# **Lime Down**

Solar Park

## **Statement of Common Ground with Natural England (Clean)**

**Document Reference: EXAM/8.4**

Drawing file: published-documents / EN010168-002331-6.2 ES Volume 2 Figure 13-11 Construction Access Locations Solar PV Sites (Rev 2).pdf

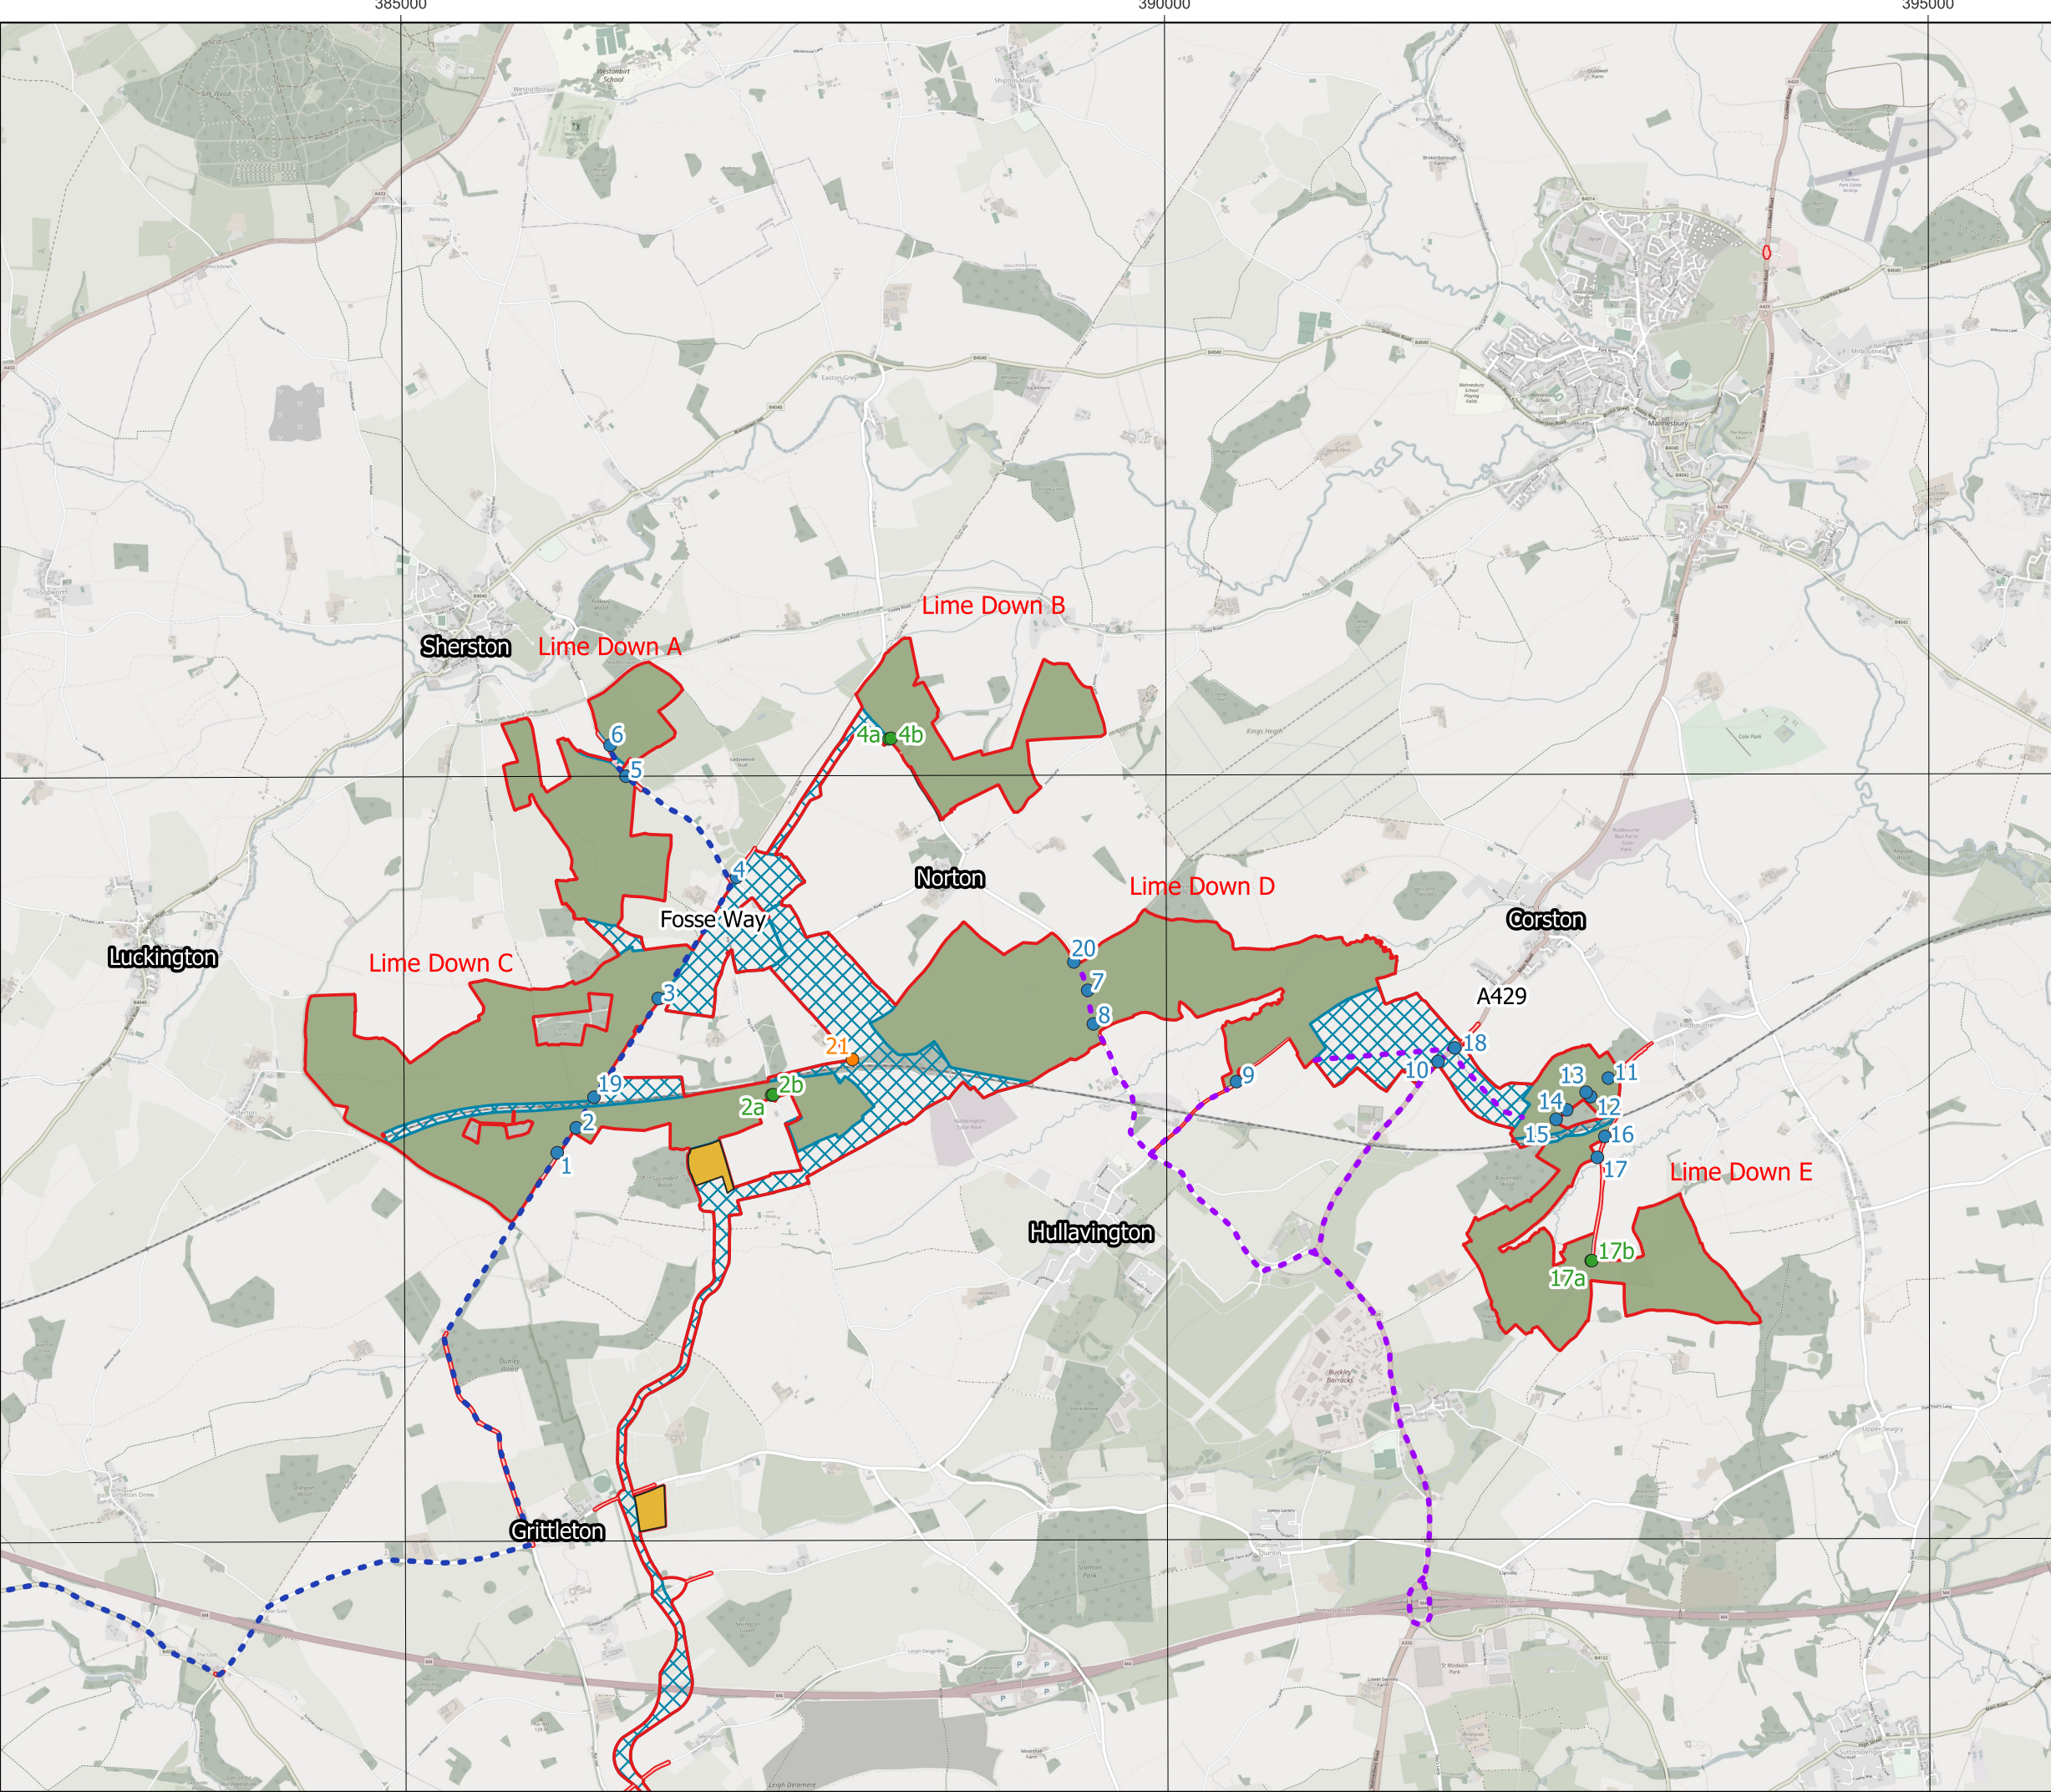
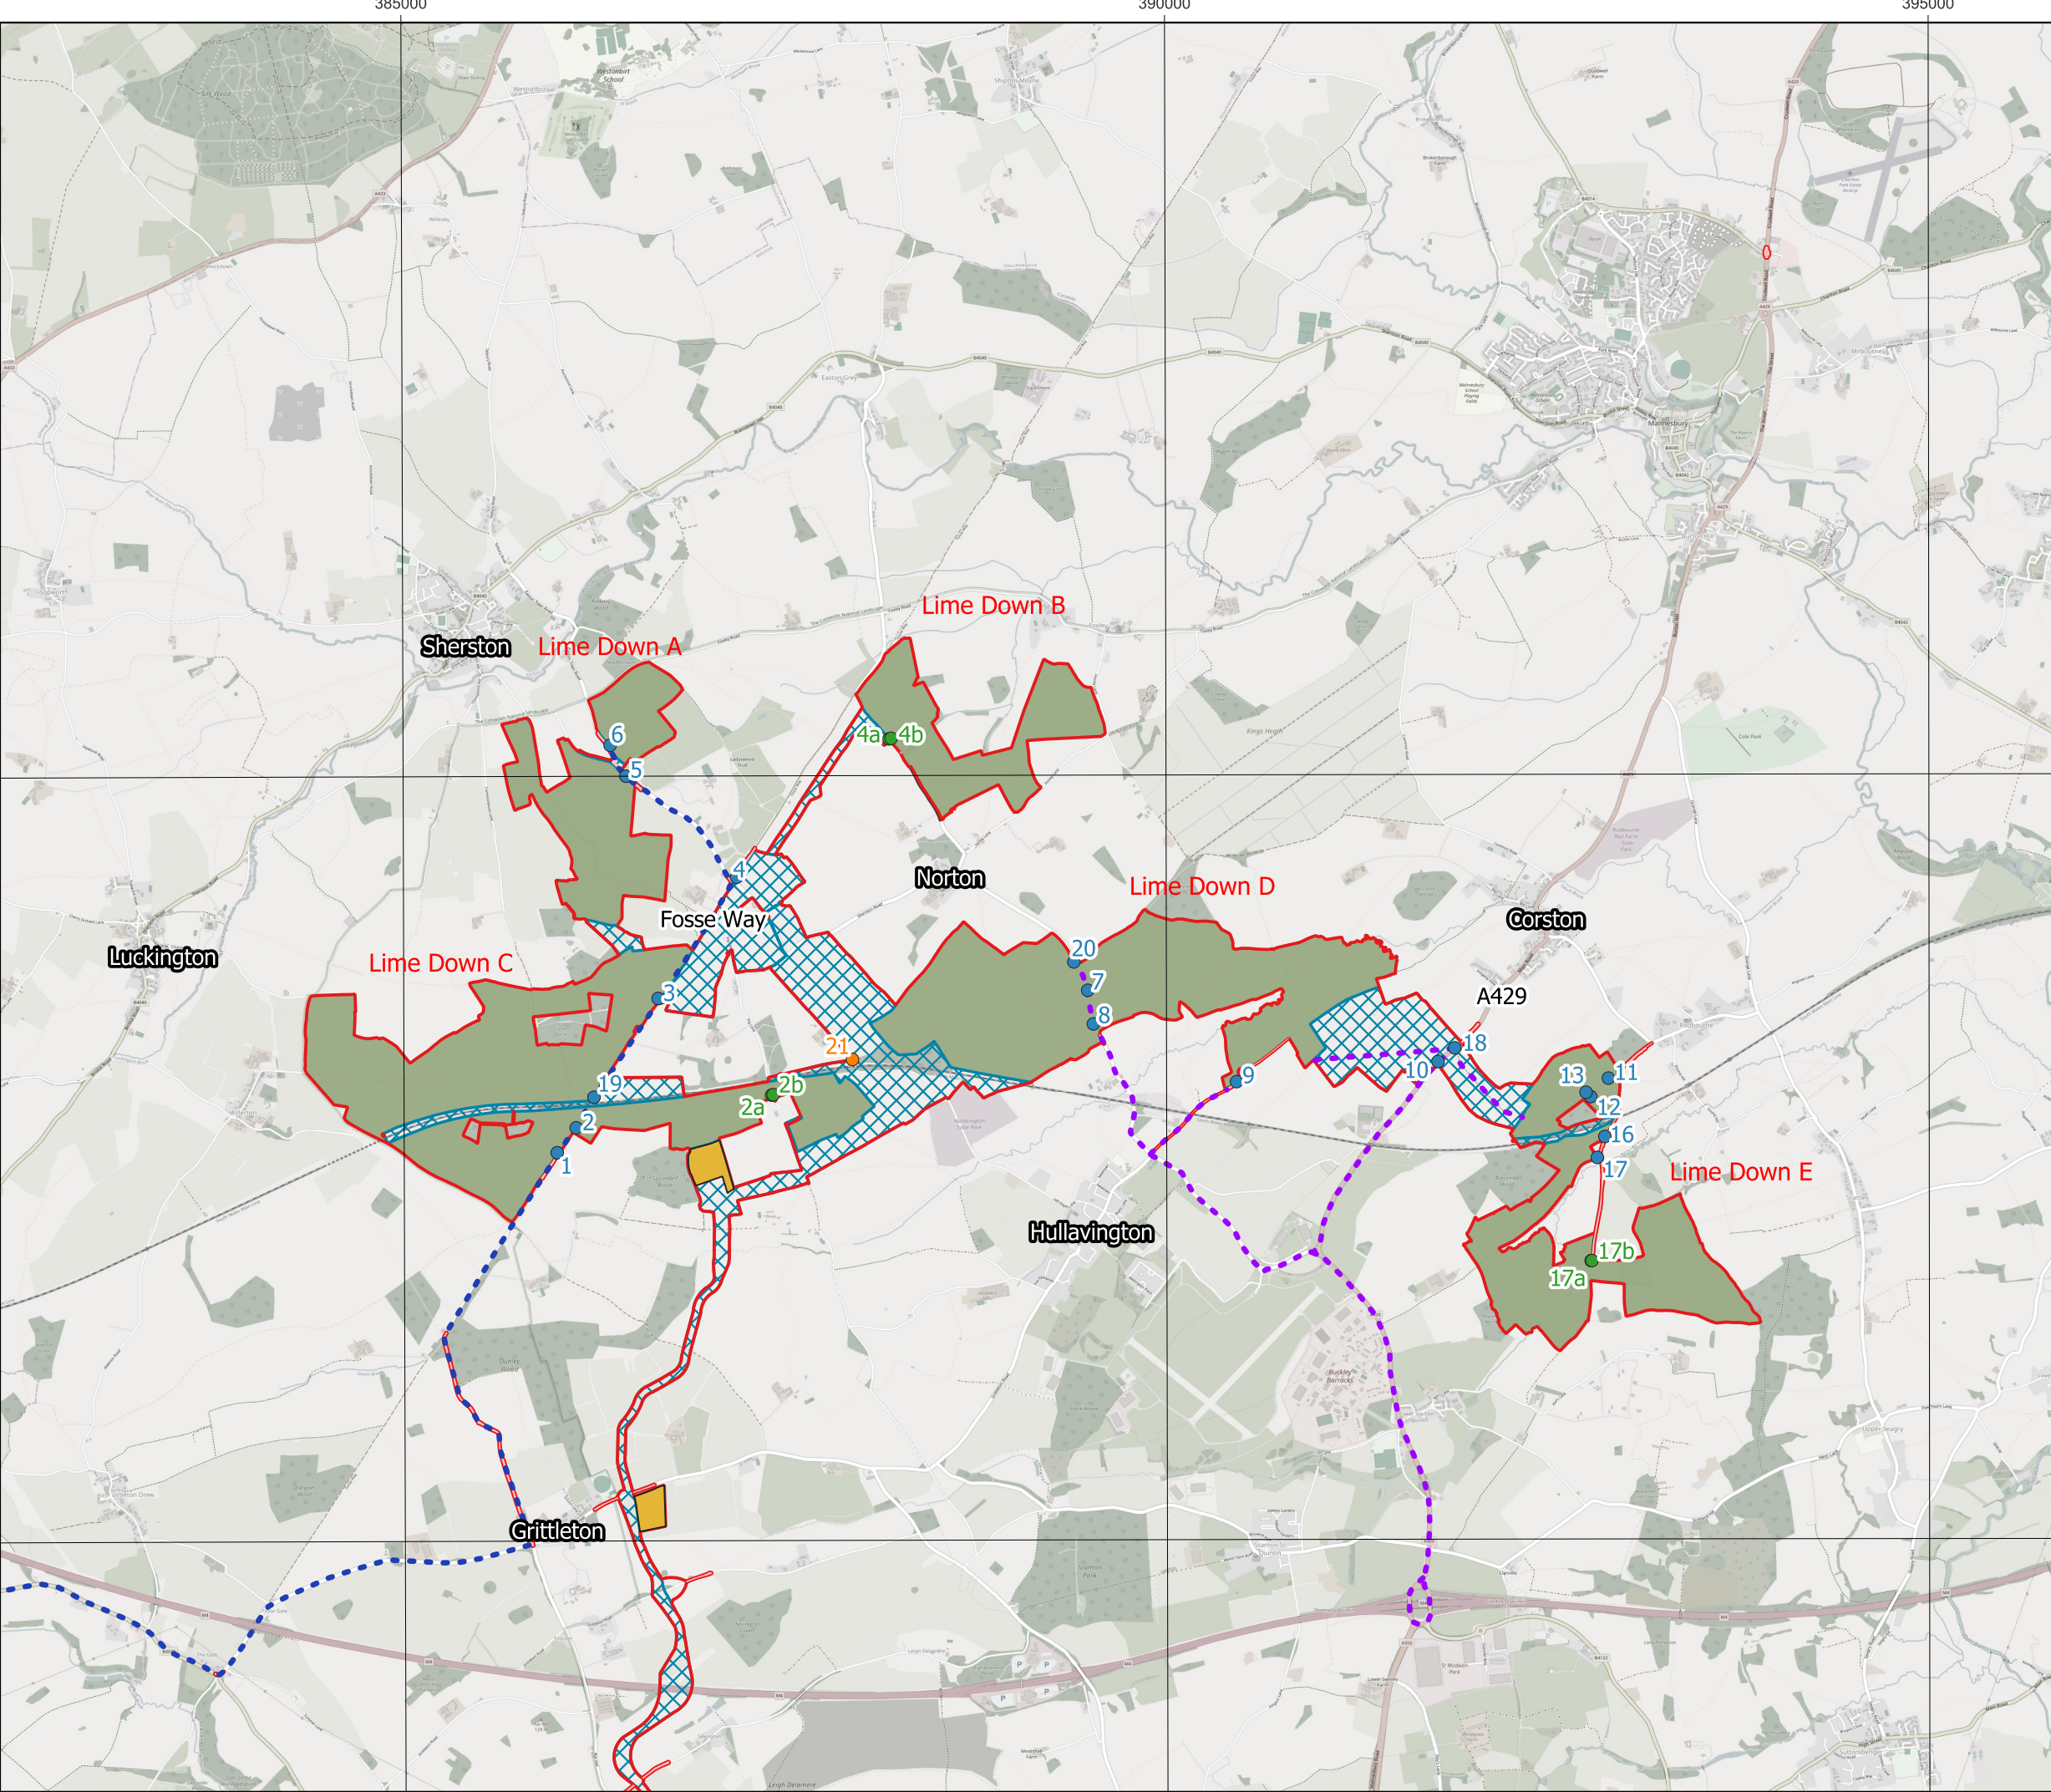
Reference	Sub-topic	NE Position	Applicants Position	Status
		<p>foraging habitat is unlikely to result in significant effects, potential fragmentation of commuting routes within Lime Down C should be screened in for Appropriate Assessment.</p> <p>For Bechstein’s bats, Natural England agrees that likely significant effects from loss or change to functionally linked land can be screened out due to distance, lack of suitable habitat, and absence of records. Evidence to date does not indicate functional linkage to the SAC, and impacts related to fragmentation, roost loss, or killing and injury are considered unlikely.</p> <p><b>Updated Position</b></p> <p>It is agreed that a vast majority of the habitat within Lime Down C provides suboptimal foraging habitat for lesser horseshoe bats. It is noted that the design of the proposed development has retained a majority of the hedgerows within Lime Down C and that losses have been</p>	<p>b. Construction Lighting will be controlled to prevent light spill onto suitable commuting habitats.</p> <p>The <b>Outline Ecological Protection and Mitigation Strategy (EPMS) [REP1-106]</b> details how sections of hedgerow to be permanently removed for new internal access tracks where no existing gap is present will typically be between 3.5 m to 6 m wide, with a maximum of 10 m of hedgerow to be removed in any one location for this element of the Scheme. It also details how sections of hedgerow to be removed to provide access from the existing highway network, including for Abnormal Indivisible Loads (AIL) will require a maximum of 18 m of hedgerow loss at any one access point, although would typically be less than this at most access points. At Lime Down C one AIL Location is expected to comprise a gap of 12 – 14 m in width, at Solar PV Access Location 19 (<b>ES Volume 2, Figure 13-11 Construction Access Locations:</b></p>

Reference	Sub-topic	NE Position	Applicants Position	Status
		<p>minimised. However, due to the reasoning stated in the <i>Habitats Regulations Assessment Report</i>, we agree that likely significant effects on the Bath and Bradford on Avon Bats SAC as a result of loss of foraging habitat cannot be screened out.</p> <p>Further, whilst a majority of the hedgerows in Lime Down C have been retained, it is noted that hedgerow gaps will need to be created in a number of areas to facilitate access. Further, uncontrolled artificial lighting could impede lesser horseshoe commuting activity across the site. Therefore, due to the reasoning stated in the <i>Habitats Regulations Assessment Report</i>, we agree that likely significant effects on the Bath and Bradford on Avon Bats SAC as a result of fragmentation cannot be screened out.</p> <p>Mitigation measures for loss of foraging habitat include the establishment of 15m buffer zones to all hedgerows and woodland across the Solar PV</p>	<p><b>Solar PV Sites [APP-156]</b> refers). Appropriate limitations and controls for the use of artificial lighting during construction, designed to avoid impacts on bats and other light-sensitive species are detailed within the <b>Outline EPMS [REP1-106]</b> as well as the <b>Outline Construction Environmental Management Plan (CEMP) [REP1-096]</b>.</p> <p>Measures set out within the <b>Outline EPMS [REP1-106]</b> and the <b>Outline CEMP [REP1-096]</b> are secured by Requirements 8 and 13 respectively within the <b>Draft Development Consent Order [REP1-007]</b>.</p> <p>On 3 June 2026 the Applicant provided NE with an advanced copy of the revised <b>Habitat Regulations Assessment Report [EN010168/APP/7.10 (Rev 2)]</b> to be submitted at Deadline 3. On 12 June 2026 NE responded to confirm agreement with the revised document, and it is considered full agreement on</p>
